Wylfa Newydd Project

Request for Non-Material Change (RfNMC) no.6

Dalar Hir Park and Ride Junction Improvement

14 March 2019

Figure 1-1 Park and Ride site boundary

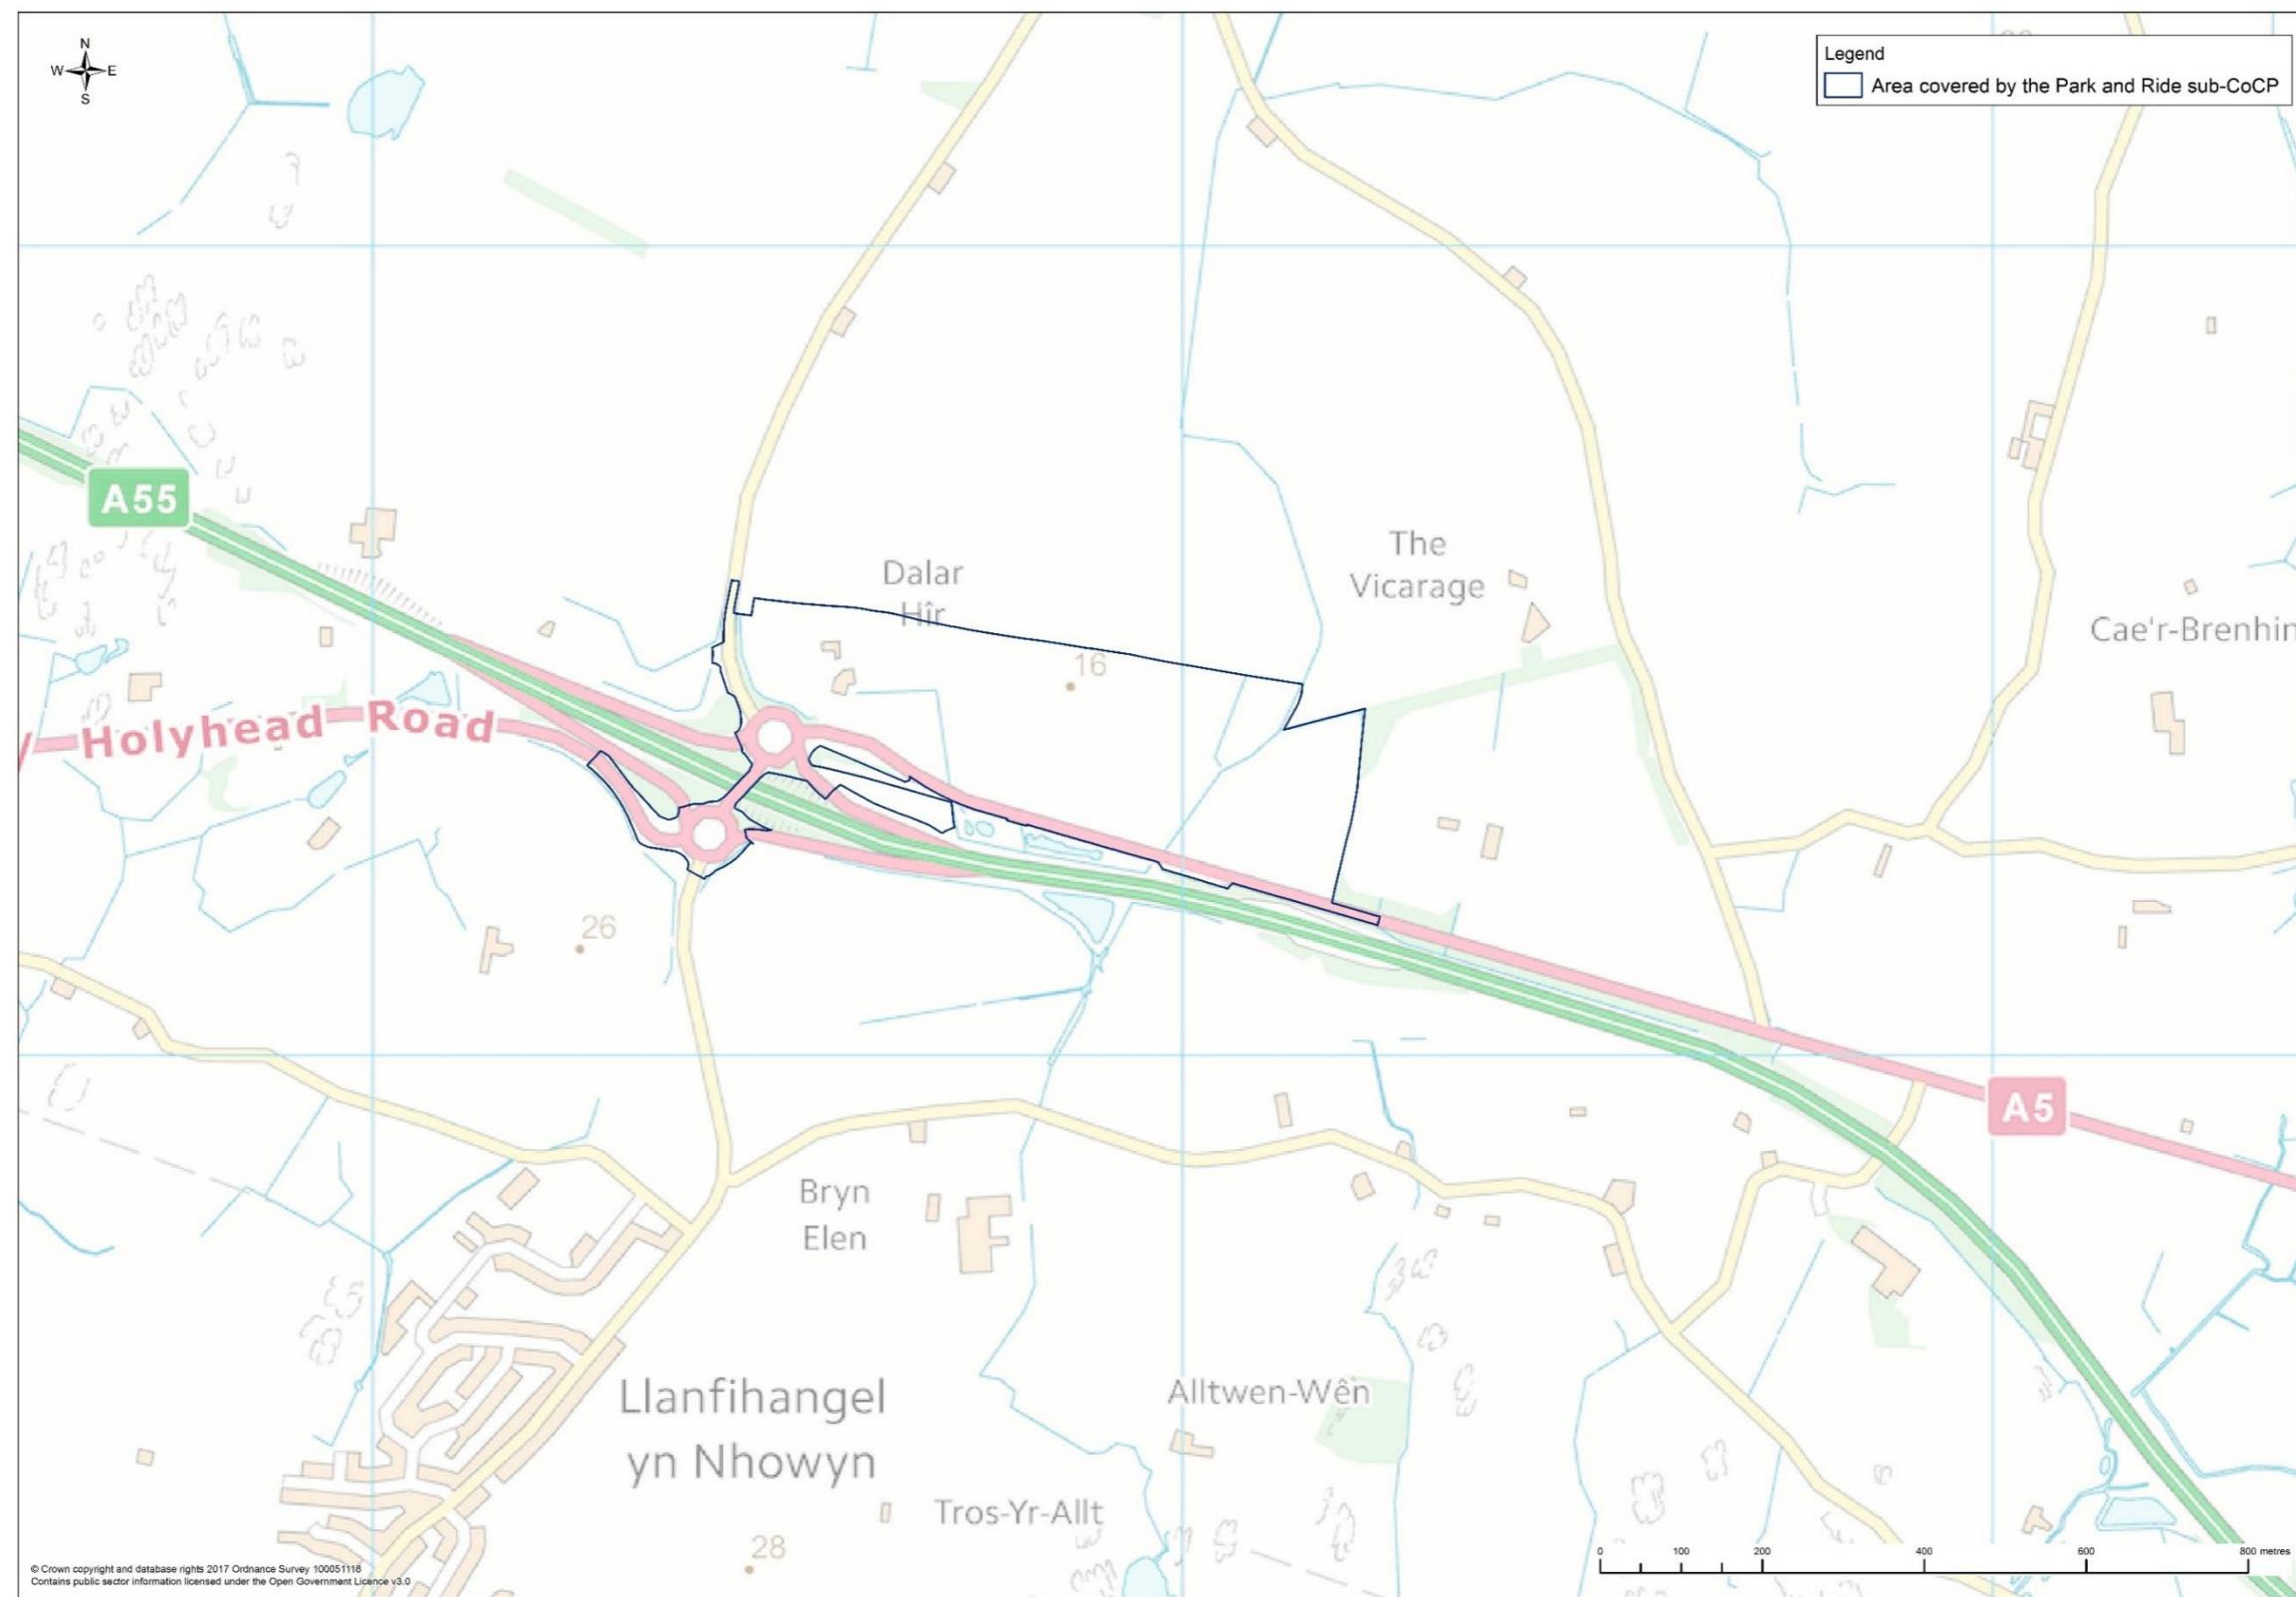
- 1.1.4 The non-material change proposed is to remove the internal roundabout at the Park and Ride, and instead to provide a single arm from the existing A5 roundabout at the A5/A55 dumbbell junction (Junction 4), as described in section 2.4 and shown in plan P 60506637/SK/54 in Appendix A. The change is proposed in order to improve junction safety and has the full support of IACC as the local highway authority. No new or different likely significant environmental effects are predicted in relation to the proposed change.

2.1.1 As noted above, the change is proposed in response to specific matters raised by IACC in the LIR submitted at Deadline 2 on Tuesday 4 December 2018. Paragraphs 1.2.34 and 1.2.35 of the LIR set out IACC's concerns with the submitted DCO plan WNO 902--HZDCO ADV DRG-00036 Rev 1.0. These concerns can be summarised as follows:

- IACC refused to accept a "departure from standard" for the forward visibility of 80 metres Stopping Sight Distance (SSD) on the approach to the roundabout from London Road south to the proposed new roundabout;
- IACC expressed safety concerns over slow moving Heavy Goods Vehicles (HGVs) negotiating the right-hand turn out of the VOSA Testing Station and crossing the western arm of the proposed roundabout, while traffic is exiting the roundabout and accelerating;
- IACC expressed further safety concerns over farm vehicles exiting onto the revised alignment of London Road and the western arm of the proposed roundabout; and
- IACC objected to the short length of highway between the existing A5 roundabout and the proposed new roundabout.

- 2.3.1 The additional leg (as shown on drawing P 60506637/SK/54 in Appendix A) provided on the north edge of the existing 70m ICD roundabout has been designed in accordance with DMRB TD16 standards. The main geometric details are as follows:
 - Carriageway centreline radius – 27.5m – this is commensurate with typical development-type roads rather than main or distributor-type roads and reinforces low speed nature of site.
 - Entry Width – 6.0m – to be marked as a single lane entry on to the roundabout for buses only; this is a continuation of the road width provided on site.
 - Entry radius – 20m – this is the desirable value entry radius for large vehicle provision in rural areas.

- Entry path curvature / deflection – circa 28m – the low centreline approach radius ensures that speeds will be low on approach and that compliance with 100m maximum is easily achieved.
- Exit width – 9.5m – this provides for separate exiting of the roundabout for public and dedicated bus traffic and is in keeping with the existing circulatory width of 10m.
- Exit radius – 20m – this is at the lower end of recommended radii but a ‘fast’ exit is not required due to low speeds within the site.
- Visibility – visibility commensurate with vehicle speeds will be available across the footpath and verge areas.

2.3.3 The existing carriageway has been widened in the vicinity of the roundabout to provide a short length (around 30m) of two-lane approach, while minimising the impact on existing features. The main geometric details are as follows:

- Carriageway centreline radius – 163m – as existing.
- Entry Width – 8.3m – to be marked as a two-lane entry on to the roundabout, left lane to A55 east (predominant flow from site) and right lane for all other movements.

- Entry radius – 20m – this is the desirable value entry radius for large vehicle provision in rural areas.
- Entry path curvature / deflection – circa 50m – the proposed changes increase the radius slightly but it is still much lower than the 100m maximum.

- Exit width – 7.0m – this is the recommended width for a normal roundabout exit and slightly larger than the existing width of 6.5m.
- Exit radius – 40m – this is the recommended radius for an exit from a roundabout of this nature.

- Visibility – the proposed changes will move the object point to a more favourable location than existing and will therefore improve existing approach visibility which appears to be around 160m, this being commensurate with an 85kph design speed.
